Memo.

Date: 7th November 2013

Subject: S6/2013/1469/FP – Oak Cottage Care Home, 4 Wilkins Green Lane,
Hatfield

Erection of single storey side and rear extension and two storey rear and side extensions

TITLE Proposed Ground & First Floor Plan		
PROJECT NAME Oak Cottage, 4 Wilkins Green Lane, Hatfield, AL10 9RT		
DRAWN BY E.B	DATE SEPT 2013	
SCALE 1:100 @ A1	CHECKED	
DRAWING NO. EL/2012/05	REV. NO. E

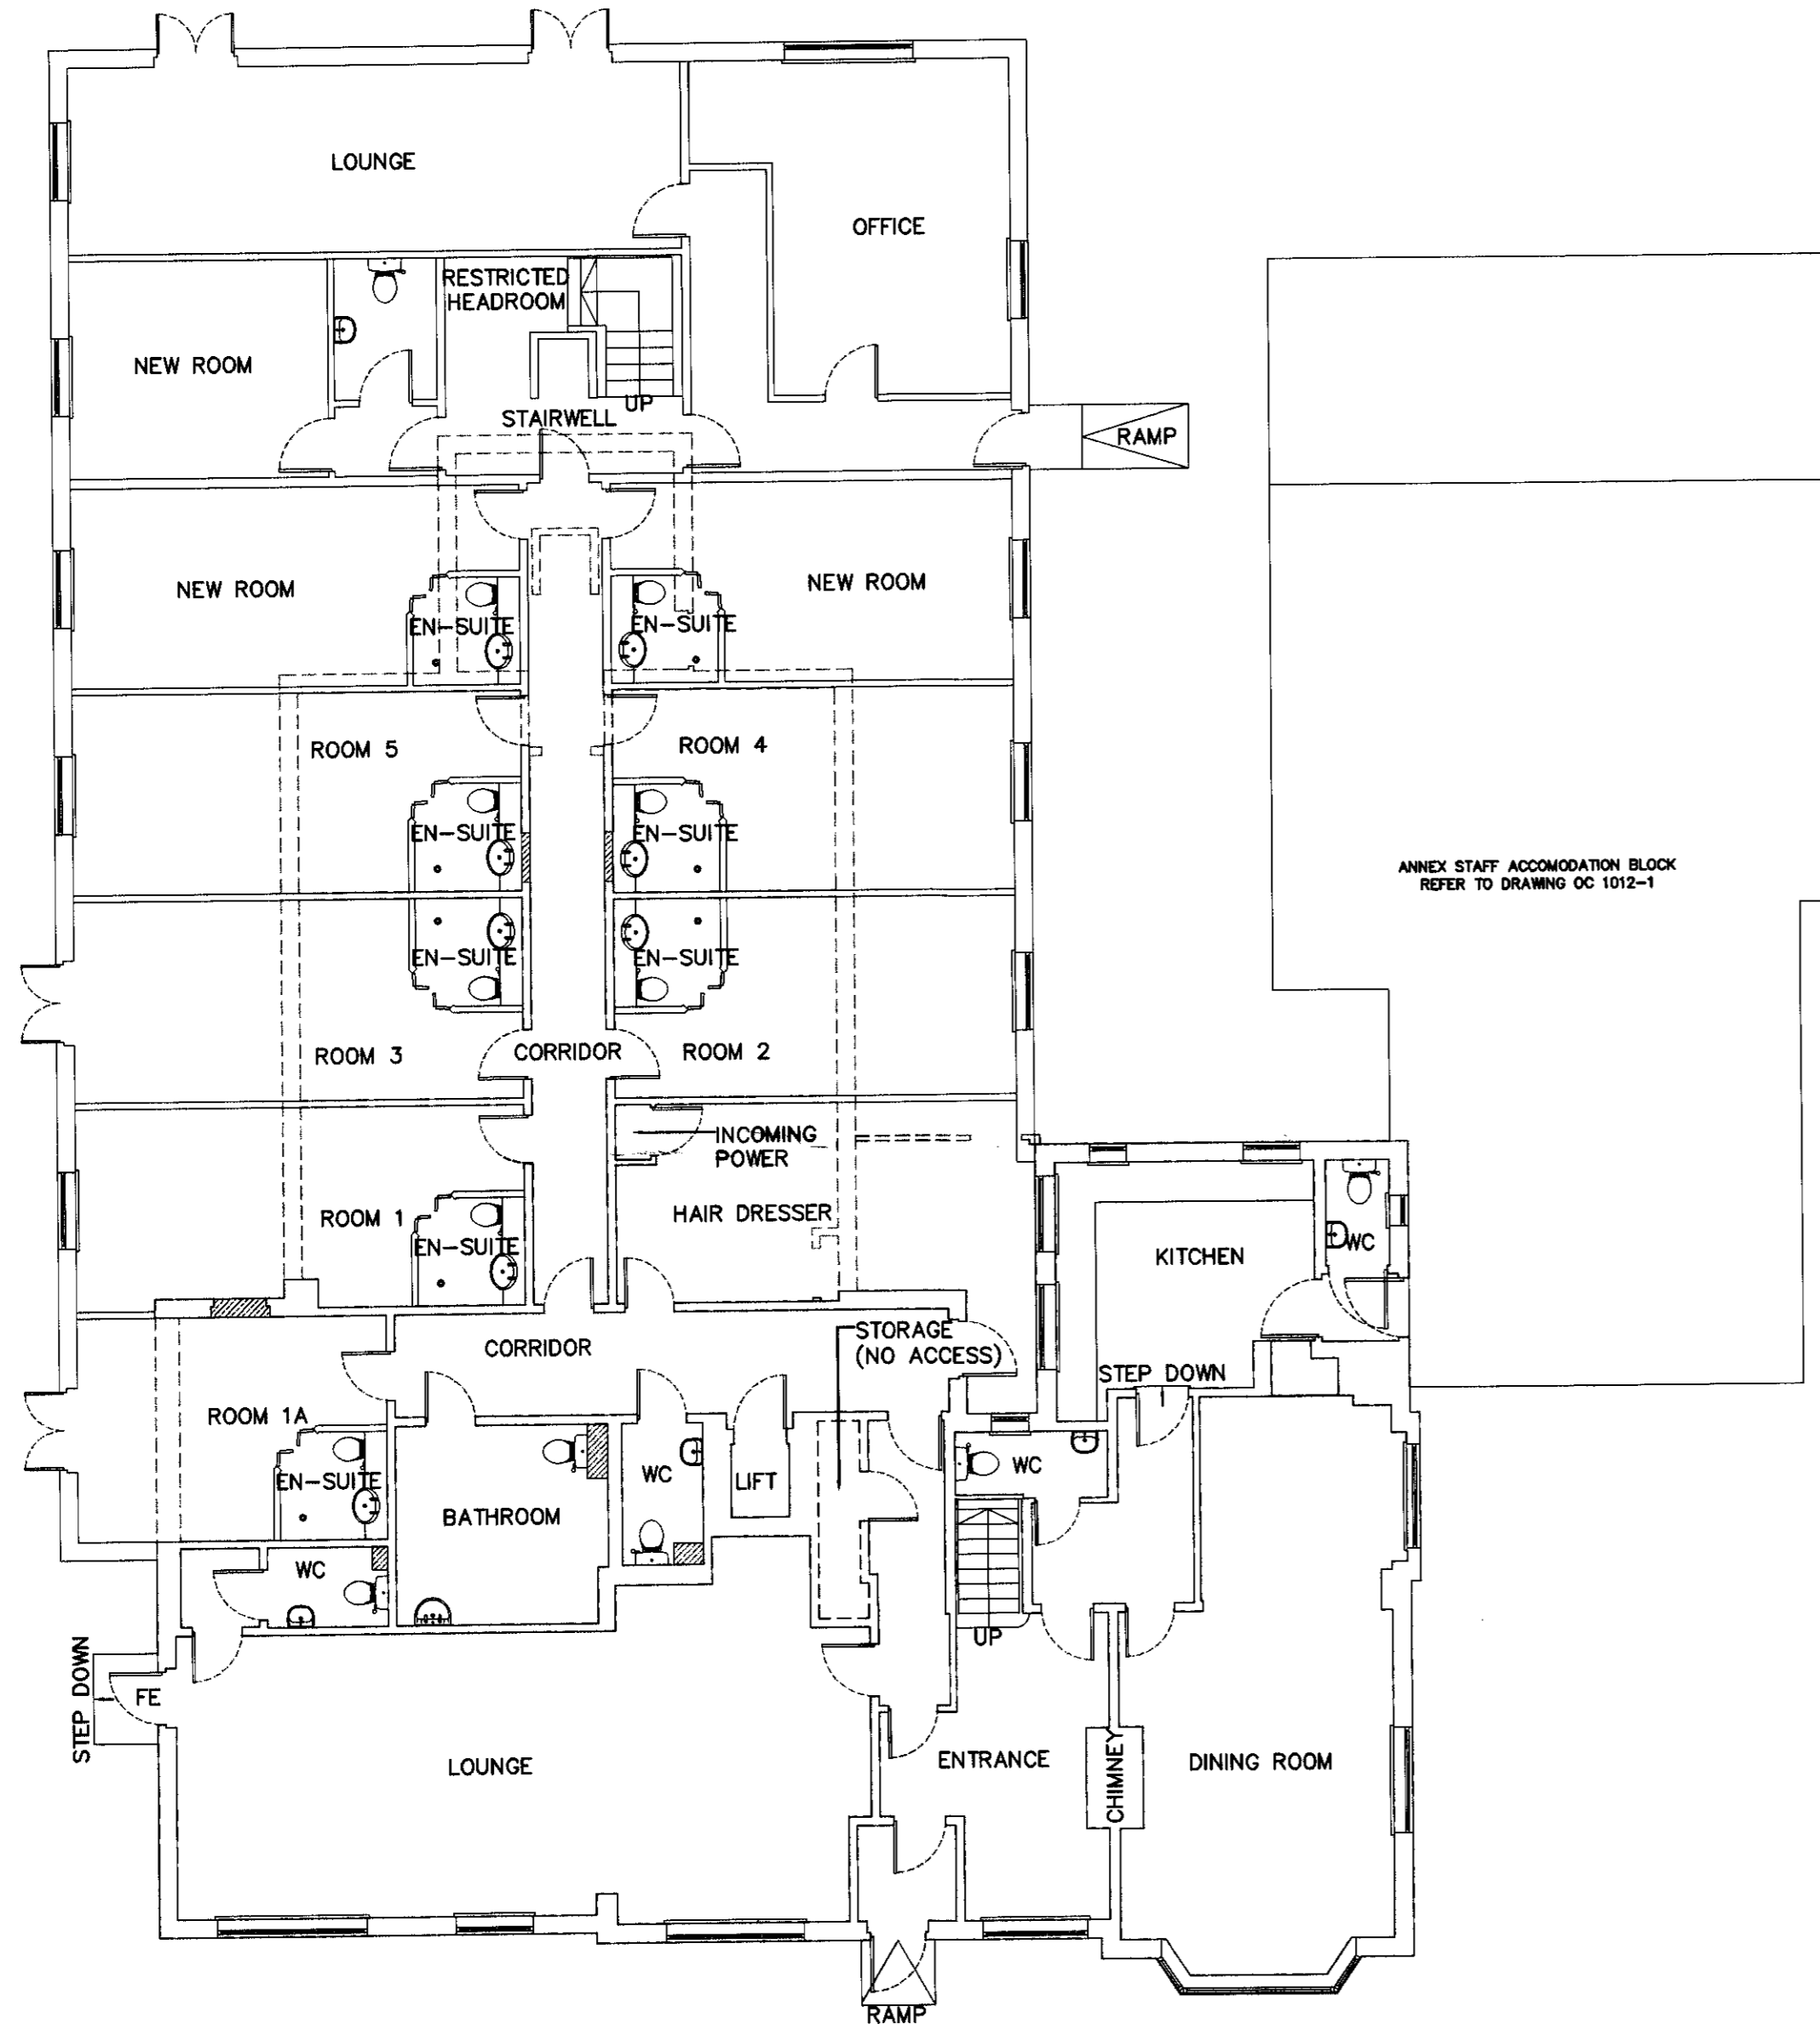
For the purposes of this planning application I have only considered the portion of the hedge between the two buildings, number 4 and 5 Wilkins Green Lane. The distance between the hedge and the western wall of building 4 is 4.1m and 6m. Small windows of habitable rooms are spaced along these walls. By considering the distance between the hedgerow and closest window (4.1m), the depth of the garden to the hedge (4.1m) and the hedges position due west, the hedgerow would, with the existing layout be subject to the high hedge recommendations under Part 8 of the Anti-social Behaviour Act 2003. Should a case be brought with the existing layout and hedge dimensions a remedial

notice would be served on the hedge owner to reduce the height to 2m. As this would be a reduction in height by 50%, dispensation would be given to undertaken this over two years, to reduce the affect of the works on the health of the plants.

The proposed layout also has two windows and two glazed doors along this wall of the building. The distance between hedge and windows would be reduced to approximately 2.5m. Although this distance is much reduced, it would not affect the desirable height of the hedge under the Act's guidelines, as 2m is considered to be a 'minimal' height for the purposes of high hedges. I would note though that the effect of the hedge on the rooms would increase.

The hedge which stands to the west of the Care Home is currently sufficiently tall to be actionable under the 'high hedge regulations' with the existing layout irrespective of the proposed layout.
